# ENG-SF21026-R3-GEC.pdf Markup Summary

SHEET: 3 OF 29

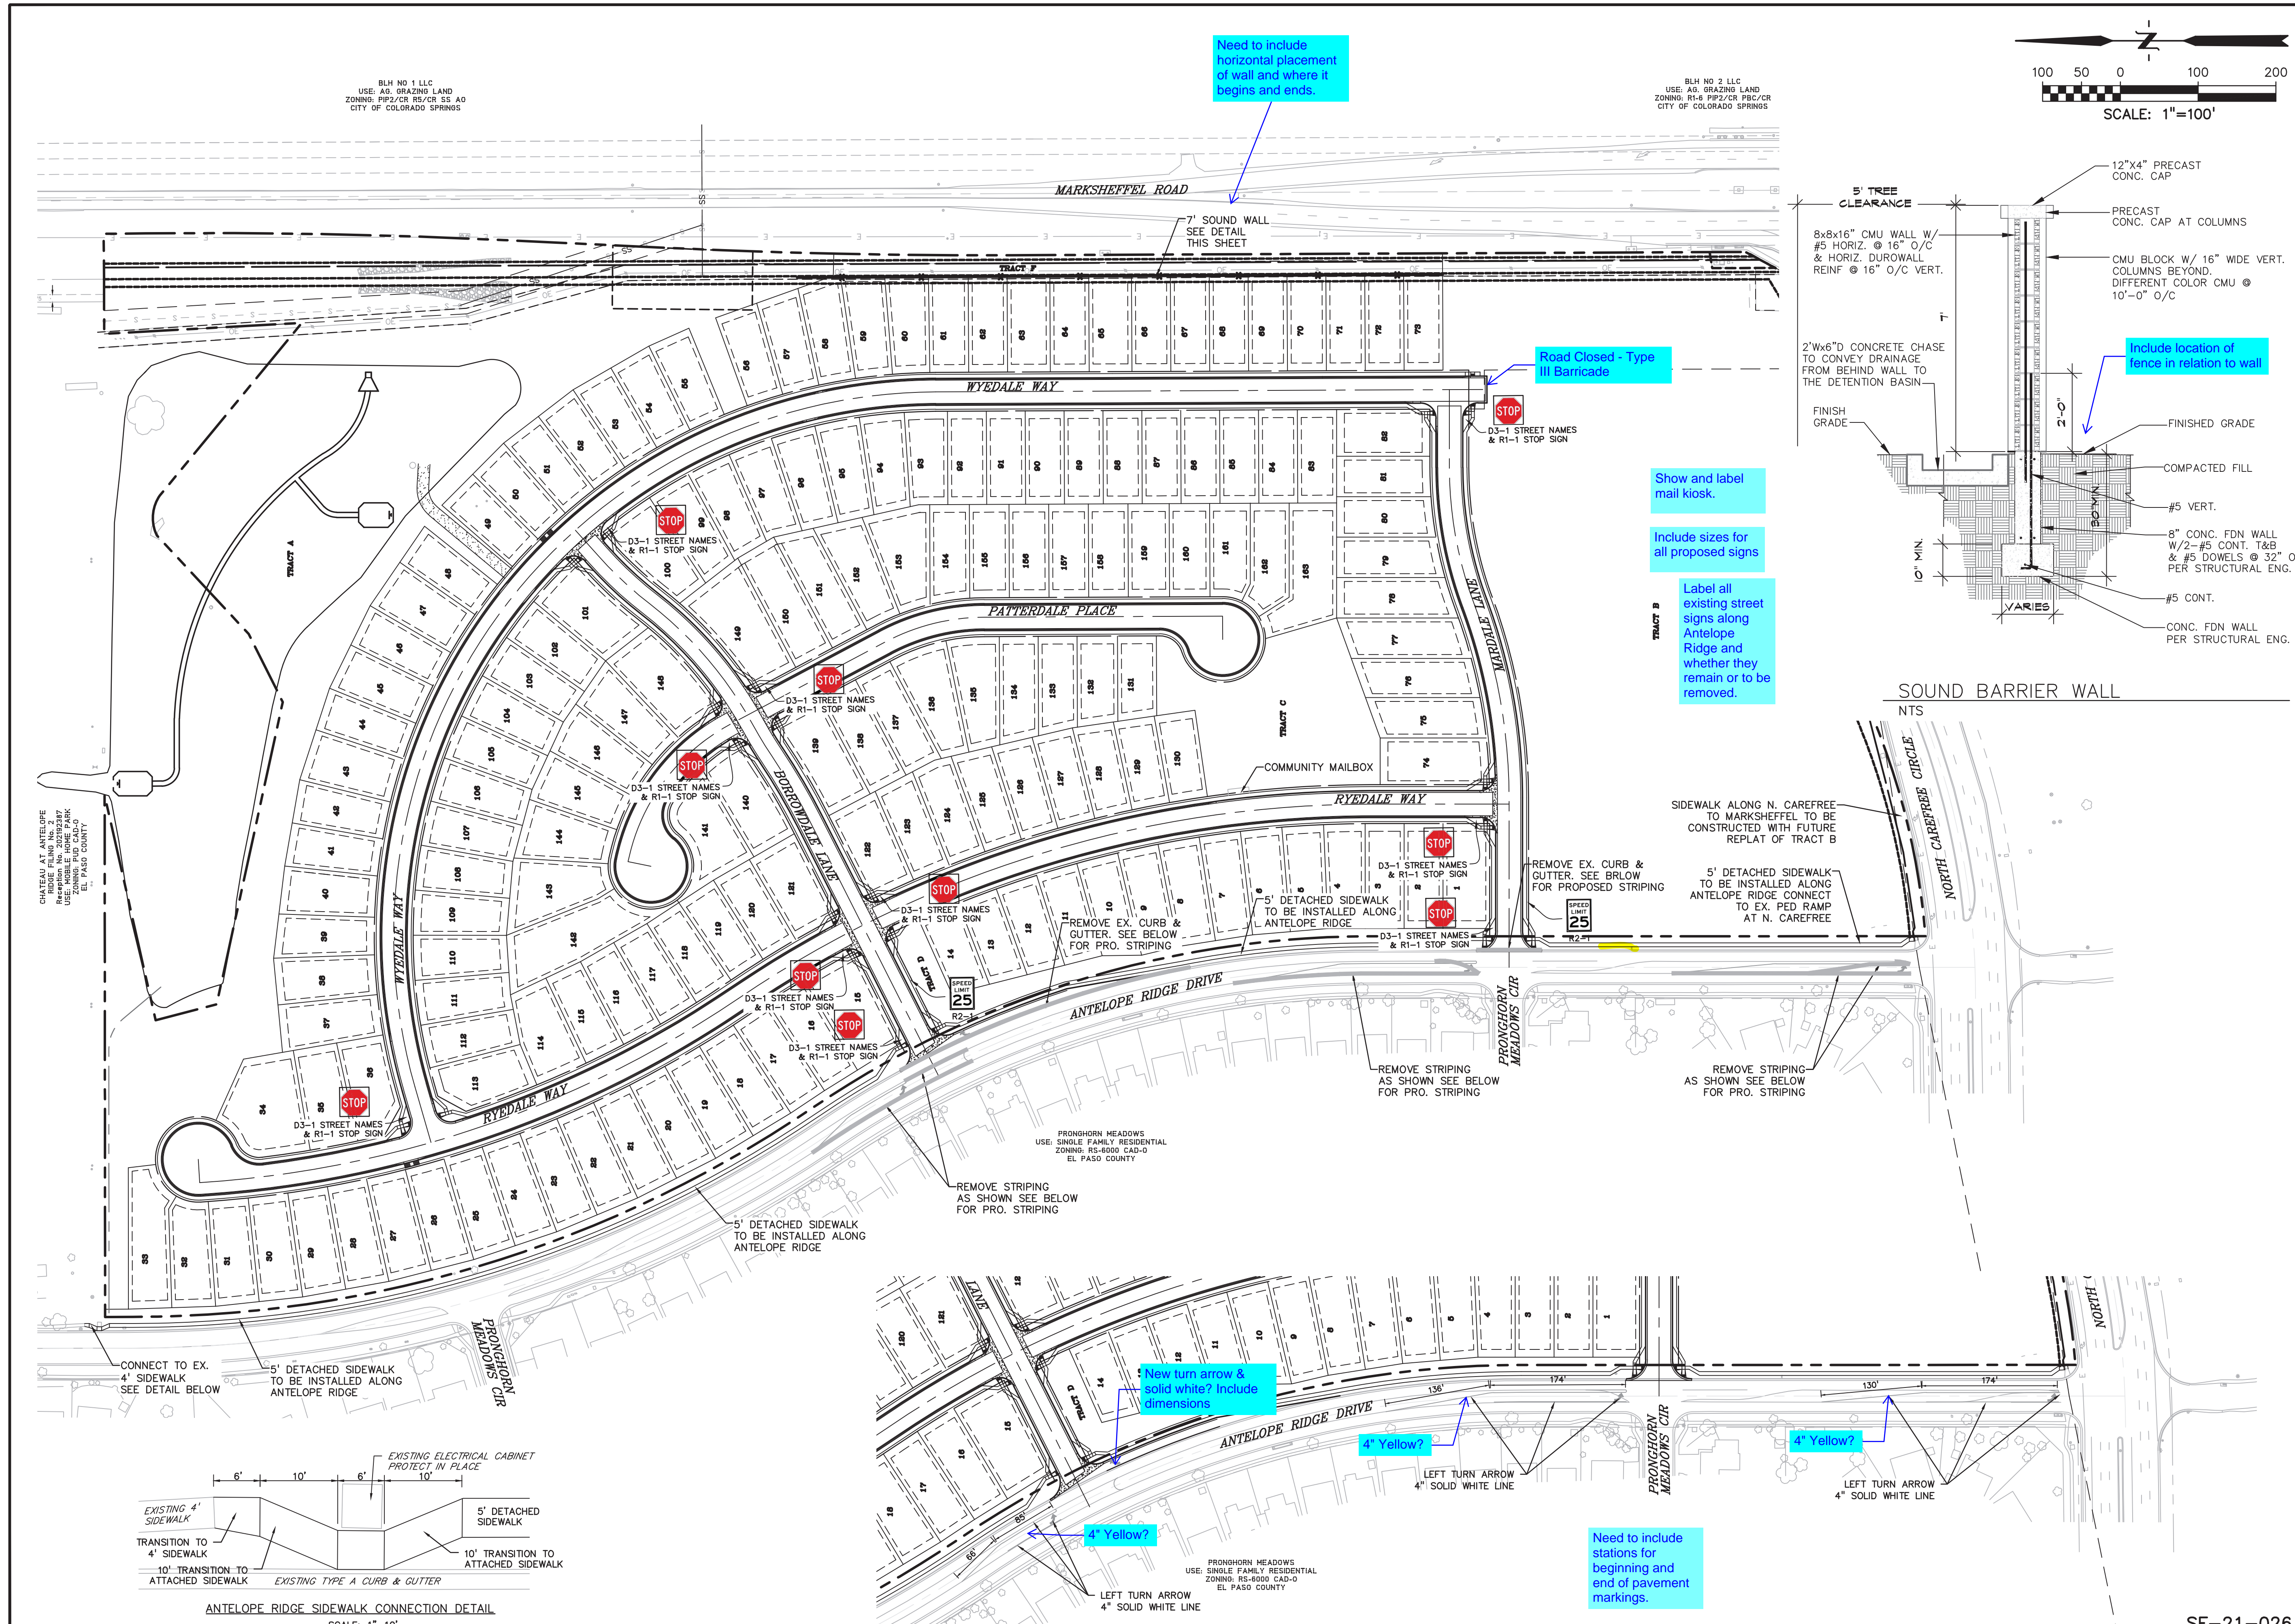
update reference

update reference

Will this pipe be abandoned?

SHEET: 8 OF 29

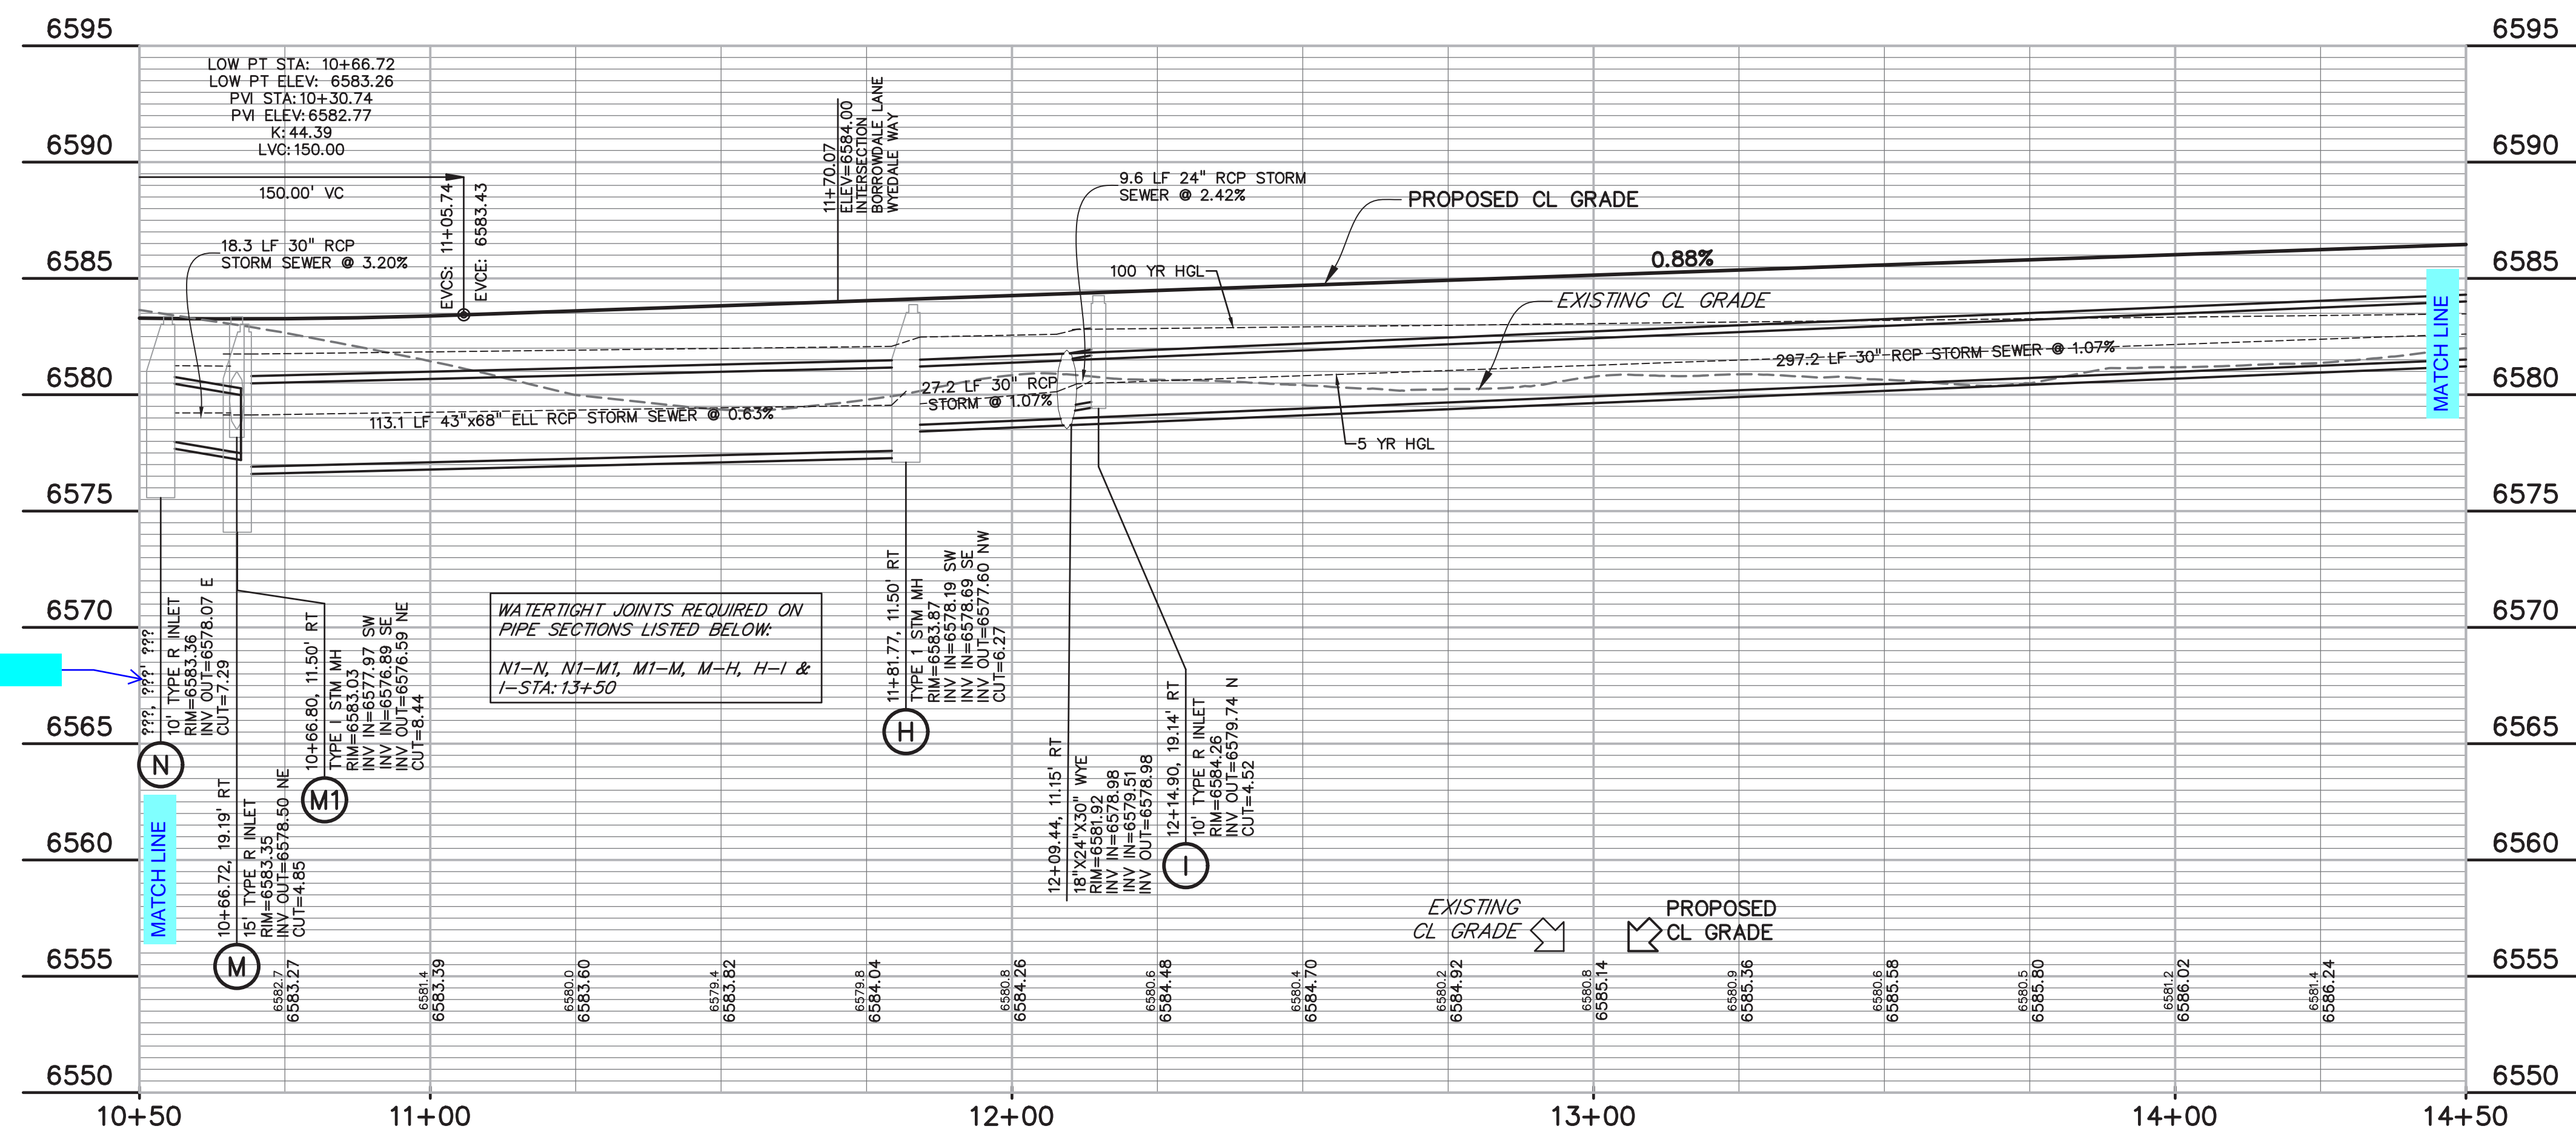
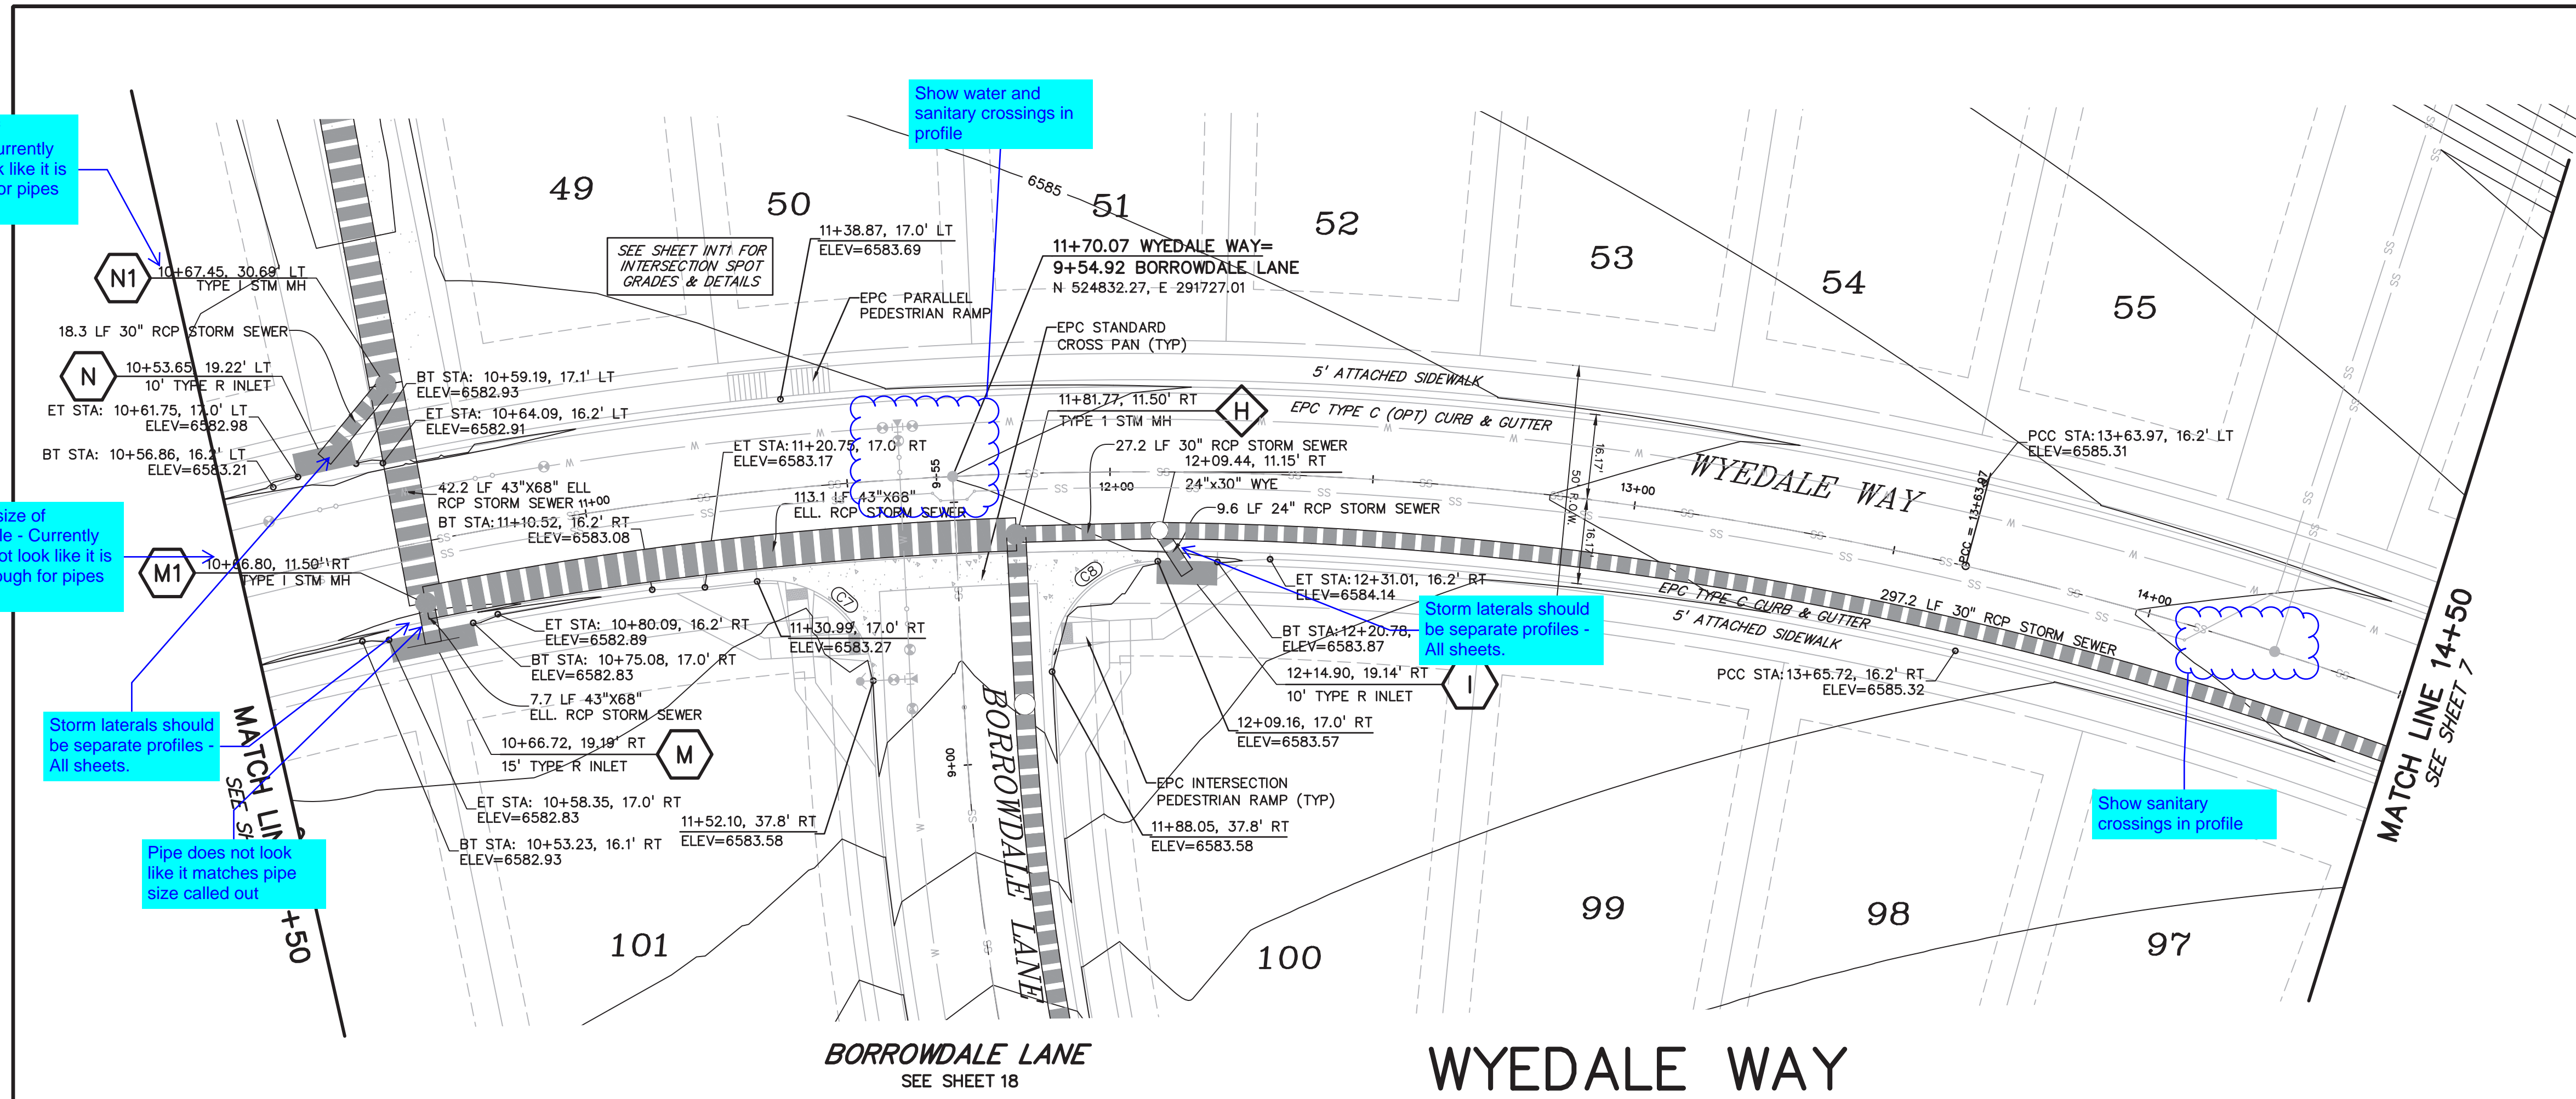
36" pipe will not fit into a Type C inlet.

Bottom of inlet at 6569.00 Please update profile

Need to see north forebay.

15' min. width for access

MHFD Spreadsheet says to use rectangular orifices not circular due to size.

Verify elevation

Verify elevation

Verify elevation

Verify elevation

Label slopes

Show HGL
